**KIRKLEES METROPOLITAN COUNCIL  
INVESTMENT & REGENERATION SERVICE**

**DELEGATED DECISION TO DETERMINE PLANNING APPLICATIONS**

Reference No:	<b>2024/62/92063/W</b>
Site Address:	45a, St Helen's Gate, Almondbury, Huddersfield, HD4 6SG
Description:	Conversion and extension of dwelling to form 8 apartments (within a Conservation Area)
Recommending Officer:	Lucy Taylor

**DECISION – REFUSED**

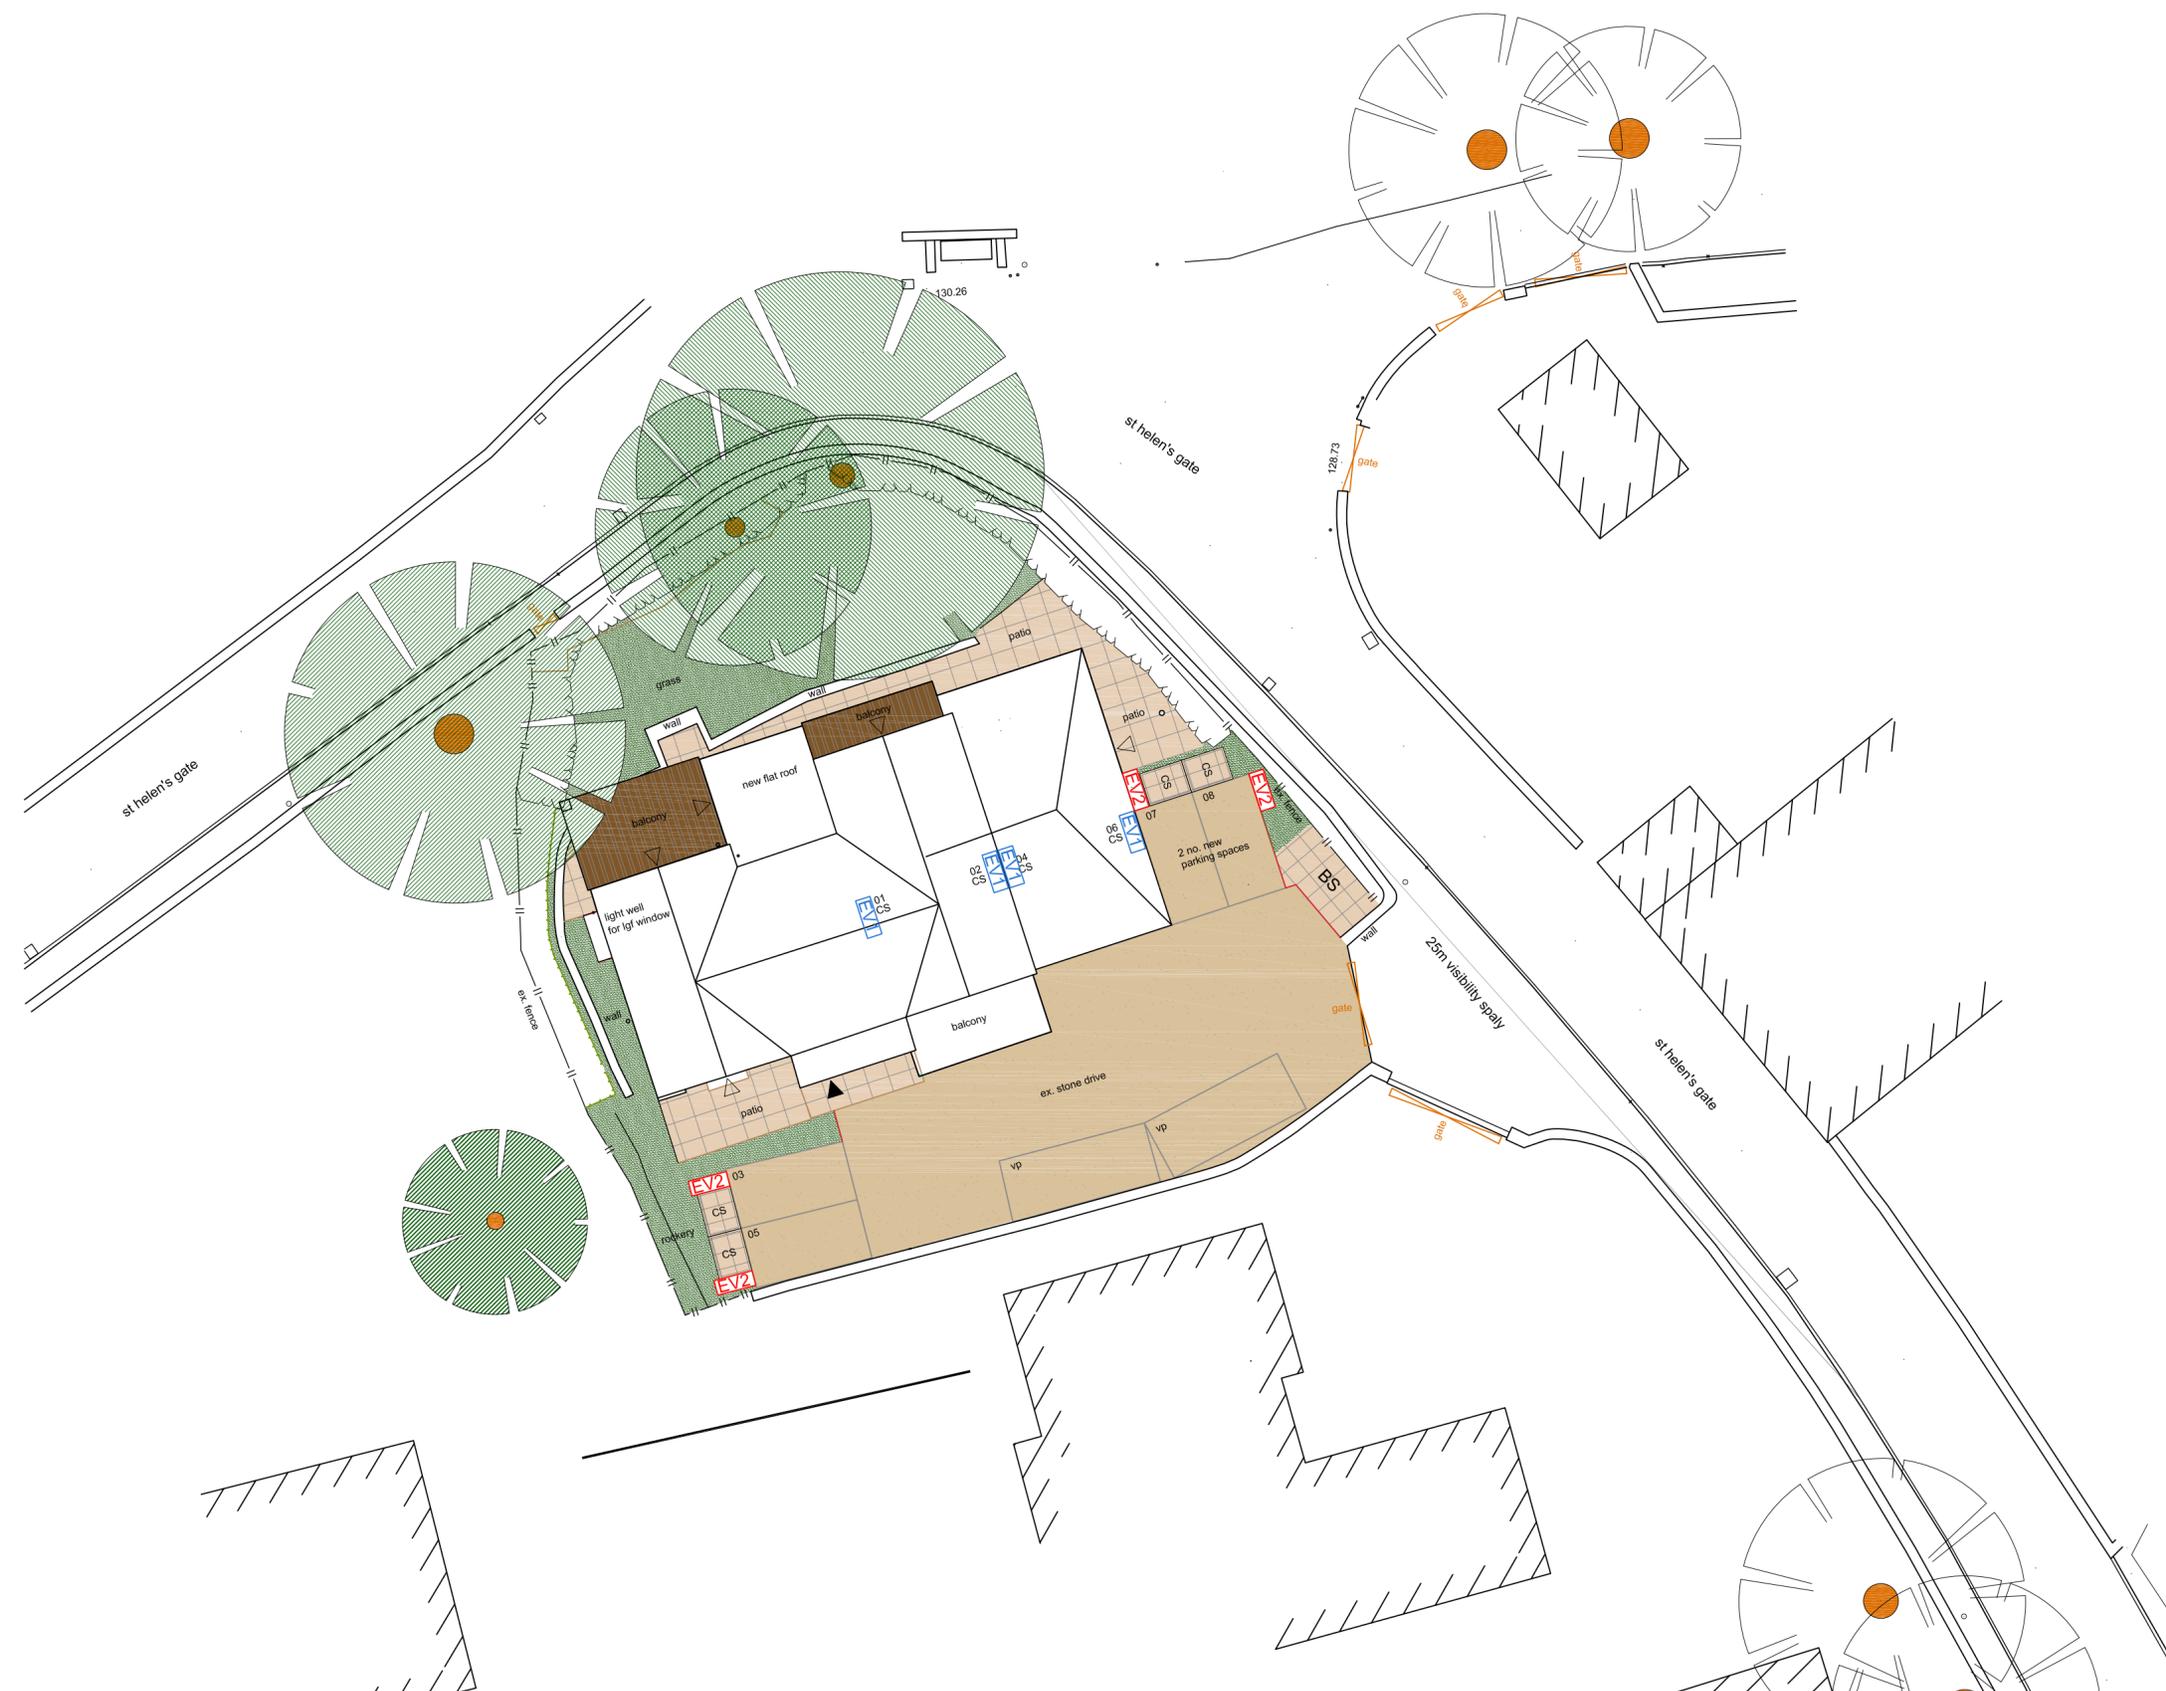
- Eight new homes would create excessive traffic in the morning, no-one cycles up the road as it is too steep. The plans show how 8 cars are squeezed in, but not how they can manoeuvre in such a tight space

- A full car park would also allow no room for the bin lorry to enter and manoeuvre so 8 bins per week would have to be left on the narrow pavement currently used by hundreds of school pupils.

**Appendix 6:
Tree Impacts Plan**

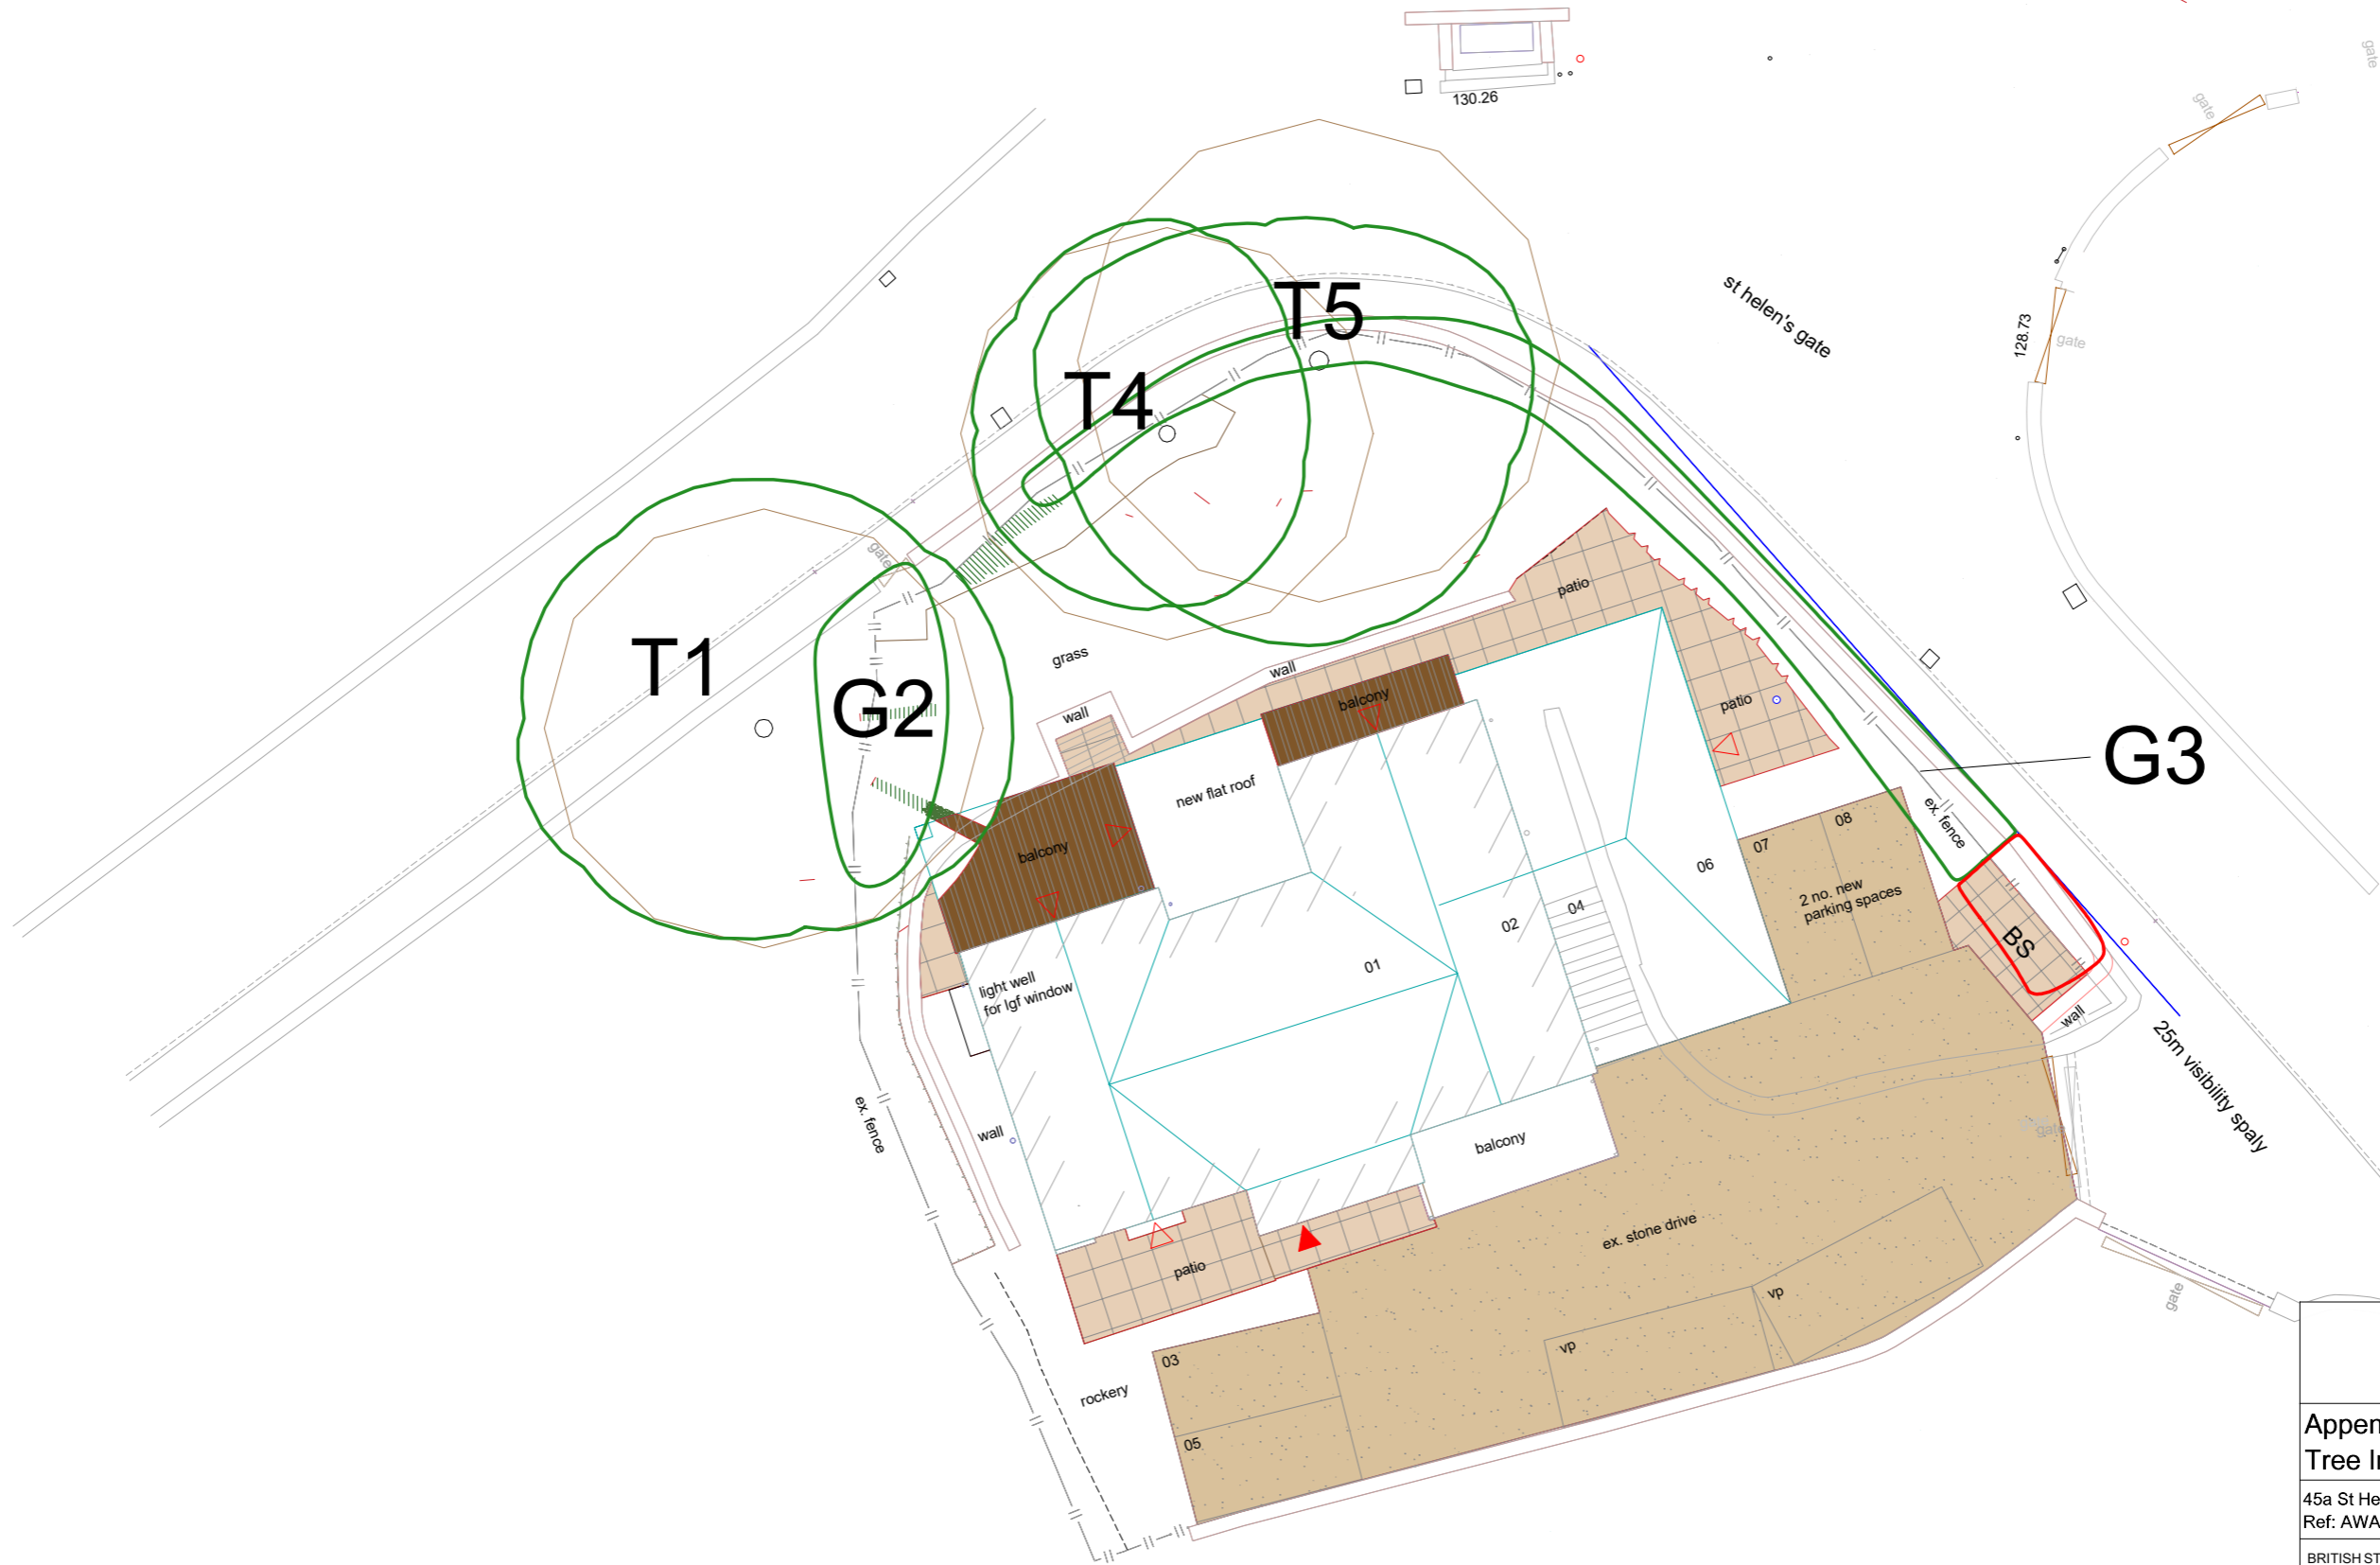
KC Trees (informal) – object, due to future pressures to fell T1, as a result of the location of the balcony, which would open up straight into the canopy of this protected tree.
